**BARNETT ADDITION  
7530 86TH AVE SE, MERCER ISLAND, WA 98040  
RESPONSE TO CITY COMMENTS**

**PROJECT NO: 20201    DATE:10/26/21  
PREPARED BY: BASRI BASRI PE, SE**

ISSUE DATE 10-26-21  
ISSUED FOR PERMIT  
PROJECT NO. 20201  
ENGINEER BB

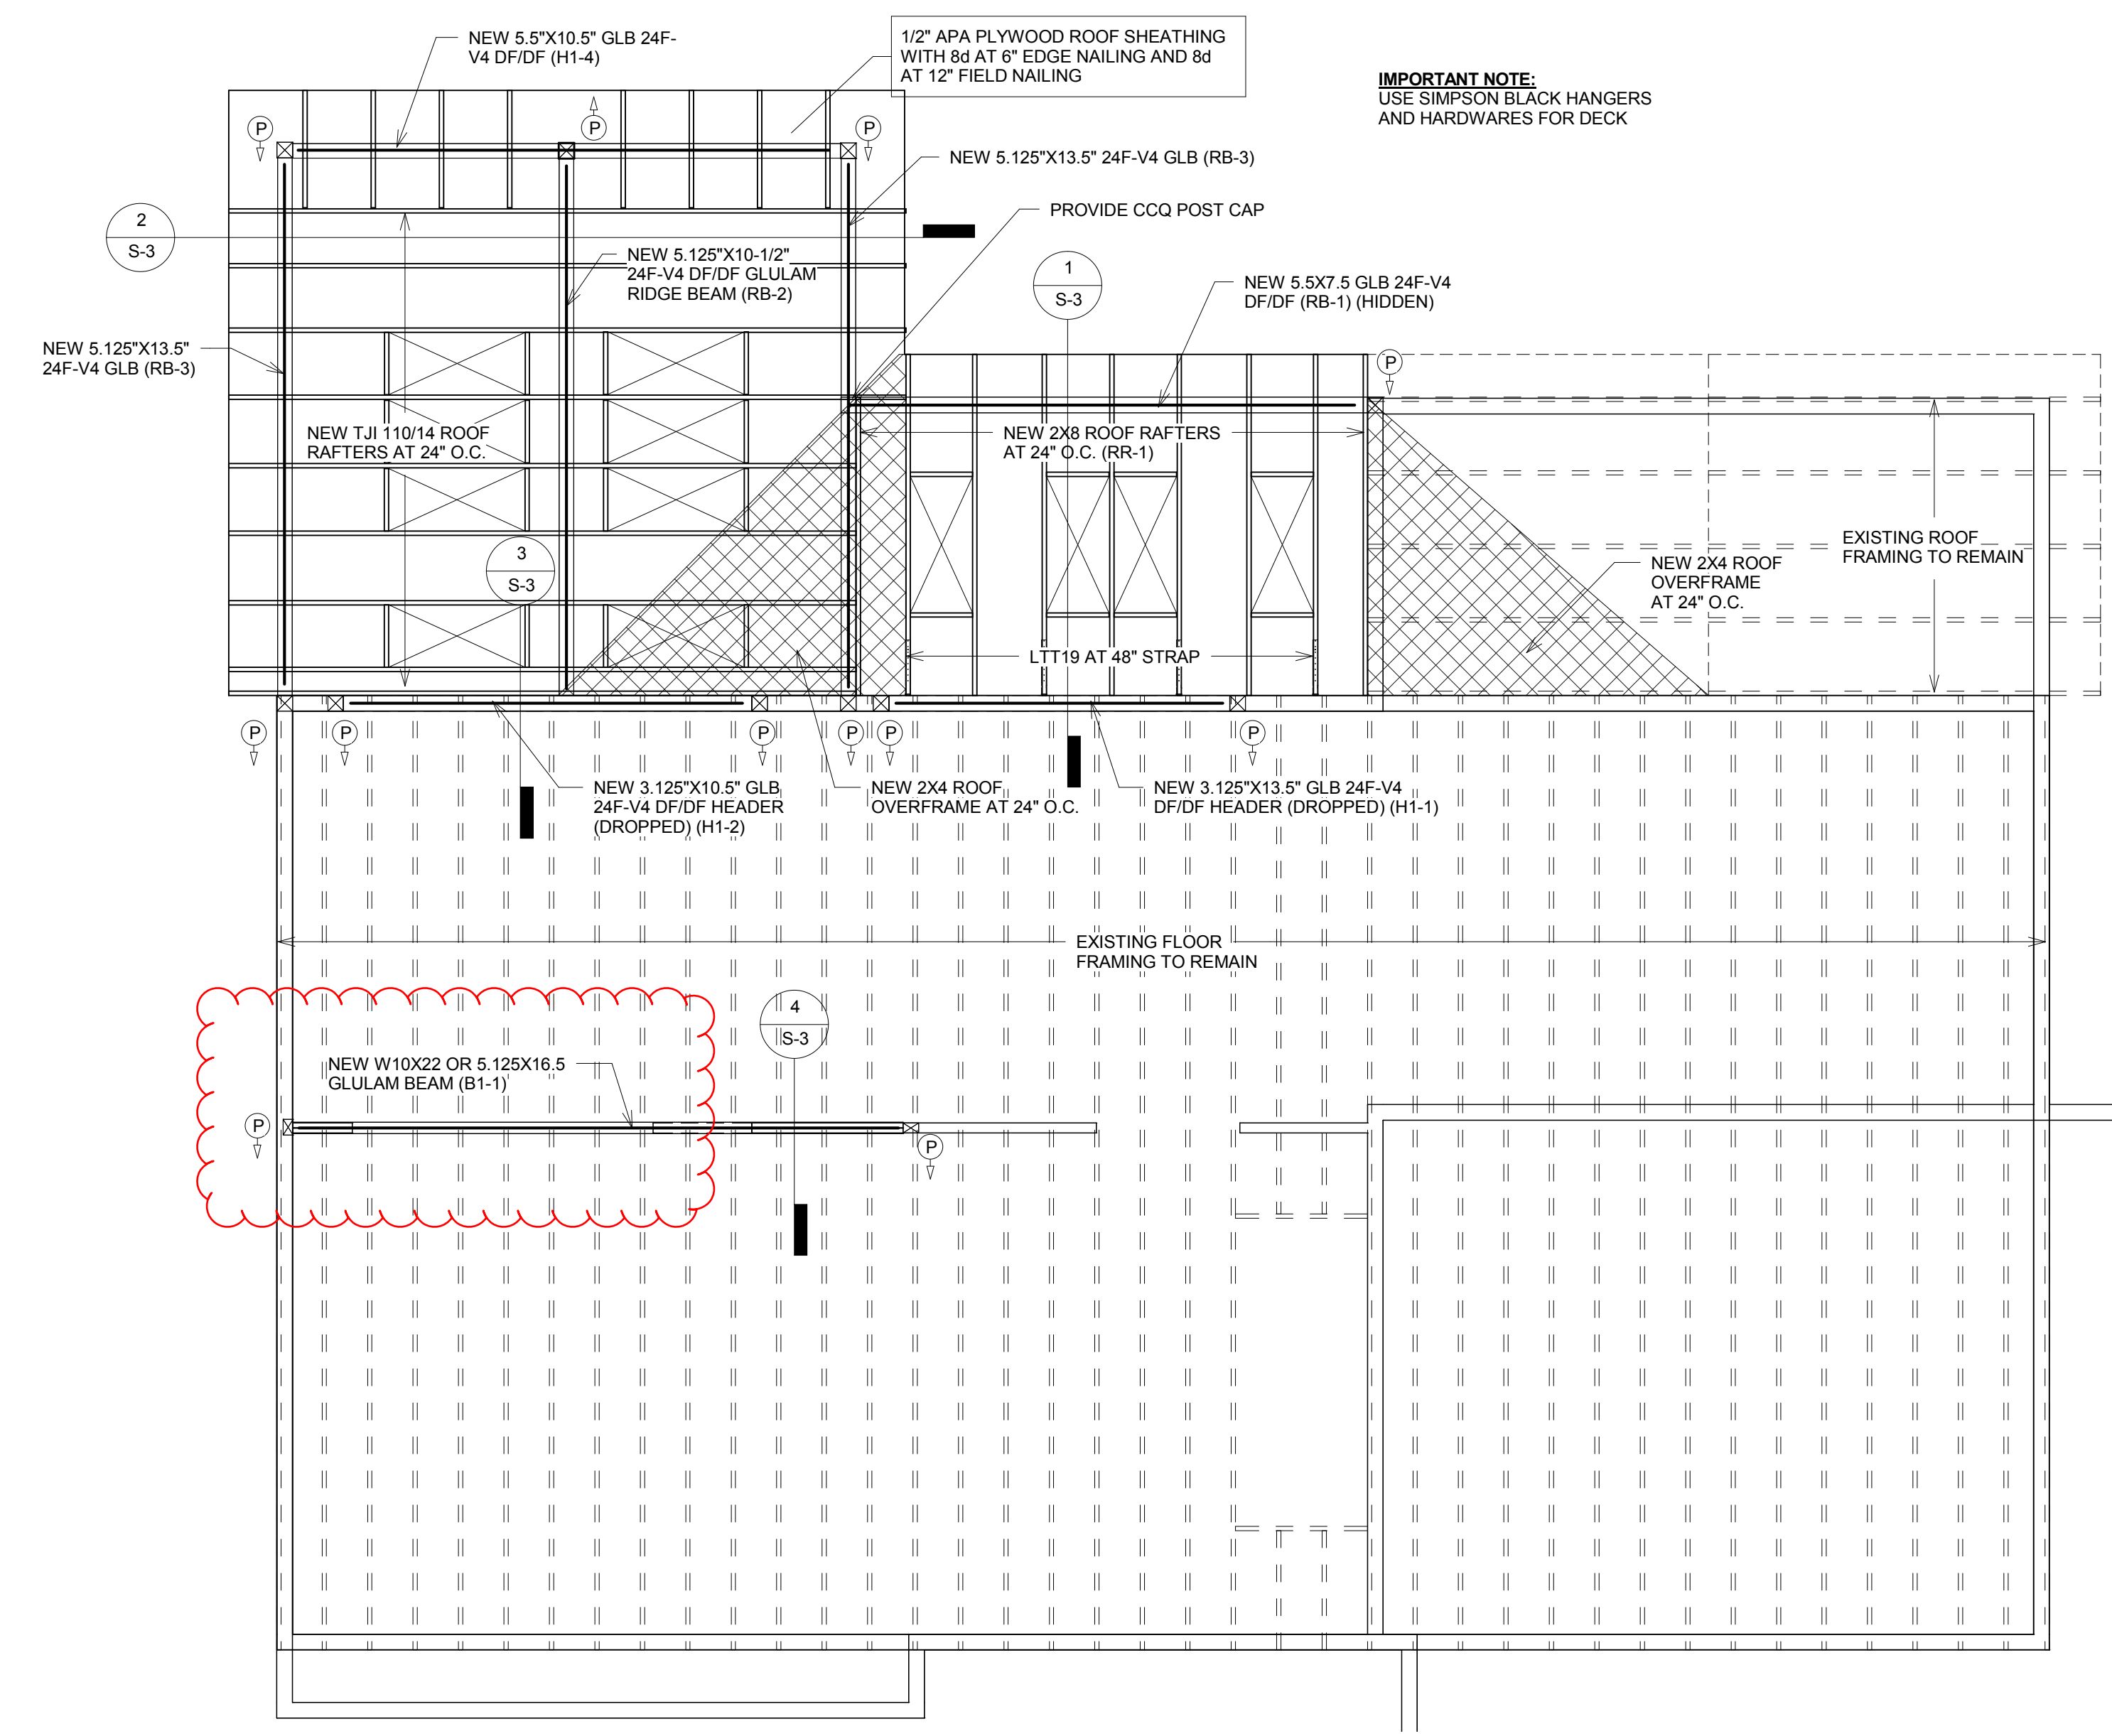
5. Please provide method to resolve lateral forces along this line. If the diaphragm is intended to cantilever, please provide a method to resolve rotational force resultant.

RESPONSE: THERE ARE (4) CANTILEVER 6X6 POSTS WITH SIMPSON RIGID POST BASE (MPB66Z) TO RESIST LATERAL FORCES ALONG THIS LINE. PLEASE SEE ATTACHED CALCULATIONS FOR POST, BASE AND FOOTING. PLEASE SEE ALSO UPDATED STRUCTURAL DRAWINGS.

6. Please revise beam design for tributary width of 15' (approximately 750 plf). Beam design B1-1 rev has the correct loading, but not the correct beam span. Beam design B1-1 has the correct span, but the wrong loading. Please confirm no roof load is supported along this line, i.e., roof framing is open web trusses bearing on the exterior walls.

RESPONSE: PLEASE SEE ATTACHED BEAM CALCULATIONS USING W10X22 STEEL BEAM OR 5.125X16.5 GLULAM BEAM
